re: Geotechnical Review
Proposed Parking Garage Access Ramp
56 Steacie Drive - Ottawa
to: Merkburn Holdings Ltd - Mr. Peter Dooher - pdooher@merkburn.com
date: June 12, 2019
file: PG4484-MEMO.02

- ☐ Project No. 18M-01672-00 - Drawing No. C-02 - Servicing Plan - Revision 2 dated April 3, 2019

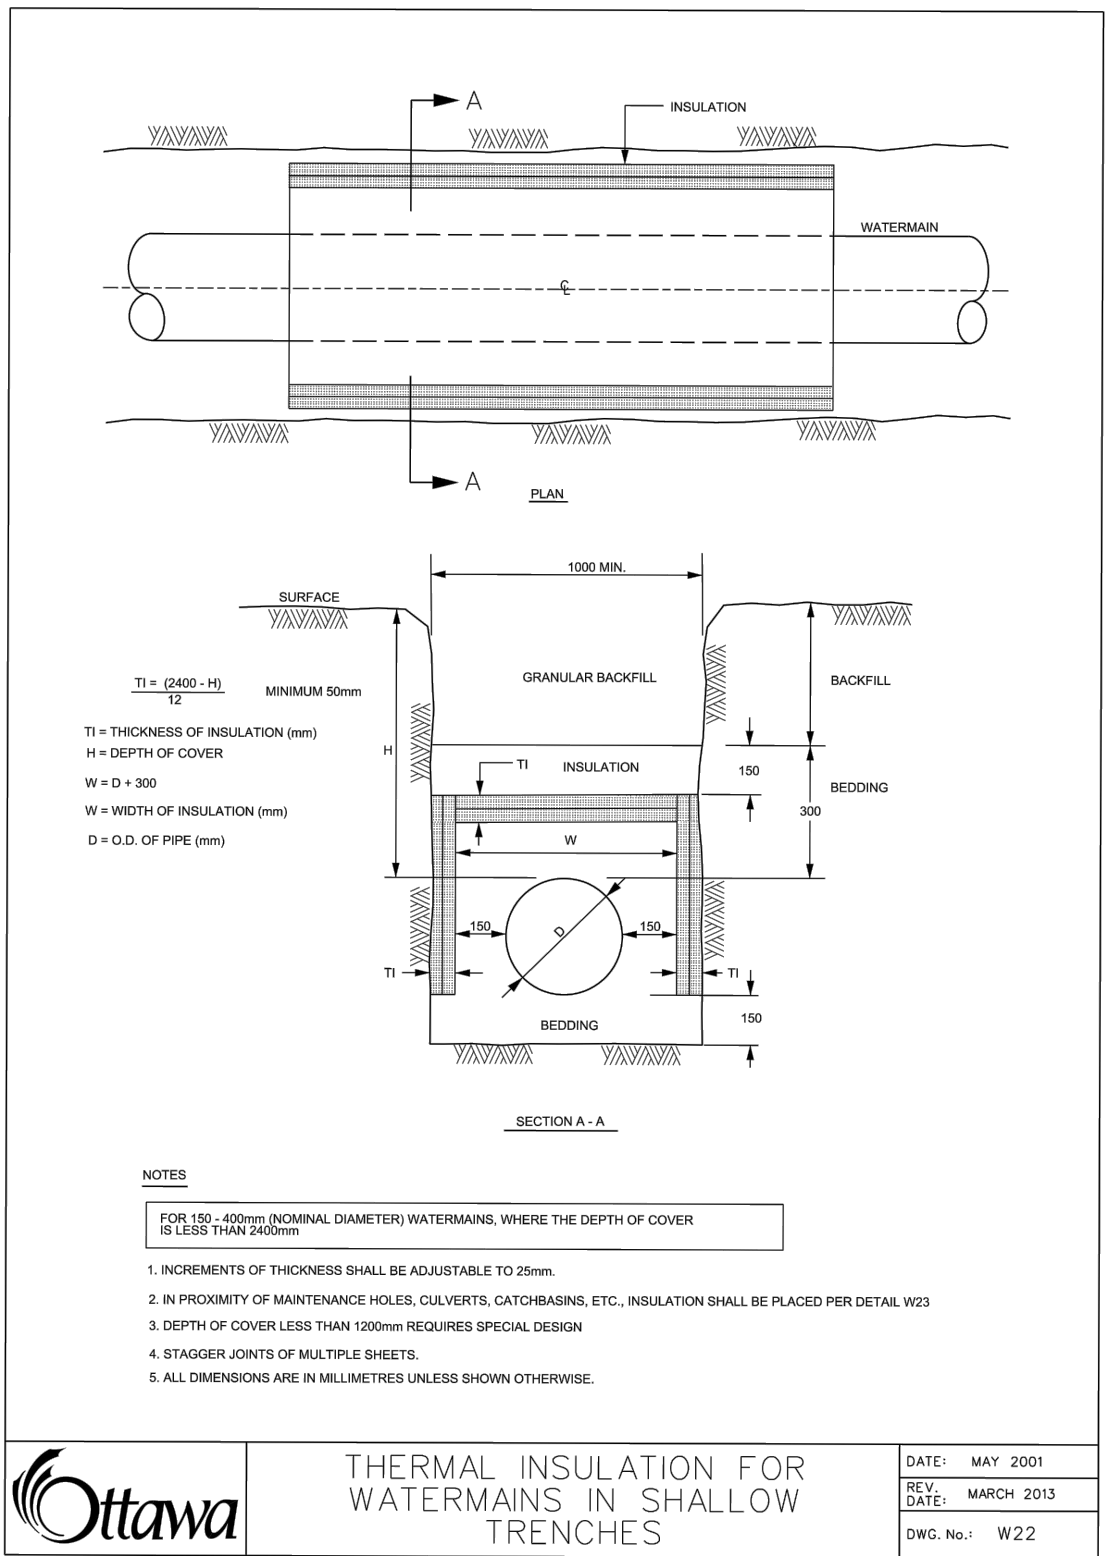
Section A on the above noted drawing shows a cross-section detail at a catch basin with an outlet to the proposed 375 mm diameter storm sewer. Based on the Section A detail, the total available frost cover above the outlet pipe is 521 mm, including the proposed 200 mm thick concrete pavement. In order to ensure adequate frost protection, it is understood that heat tracing will be provided within the concrete slab. It is further understood that the proposed outlet pipe will be wrapped with insulation resulting in a reduction of the granular material thickness for the pavement structure to approximately 270 mm below the concrete slab.

Based on our review of the above noted detail, the localized reduction in pavement structure granular thickness is considered acceptable from a geotechnical perspective.
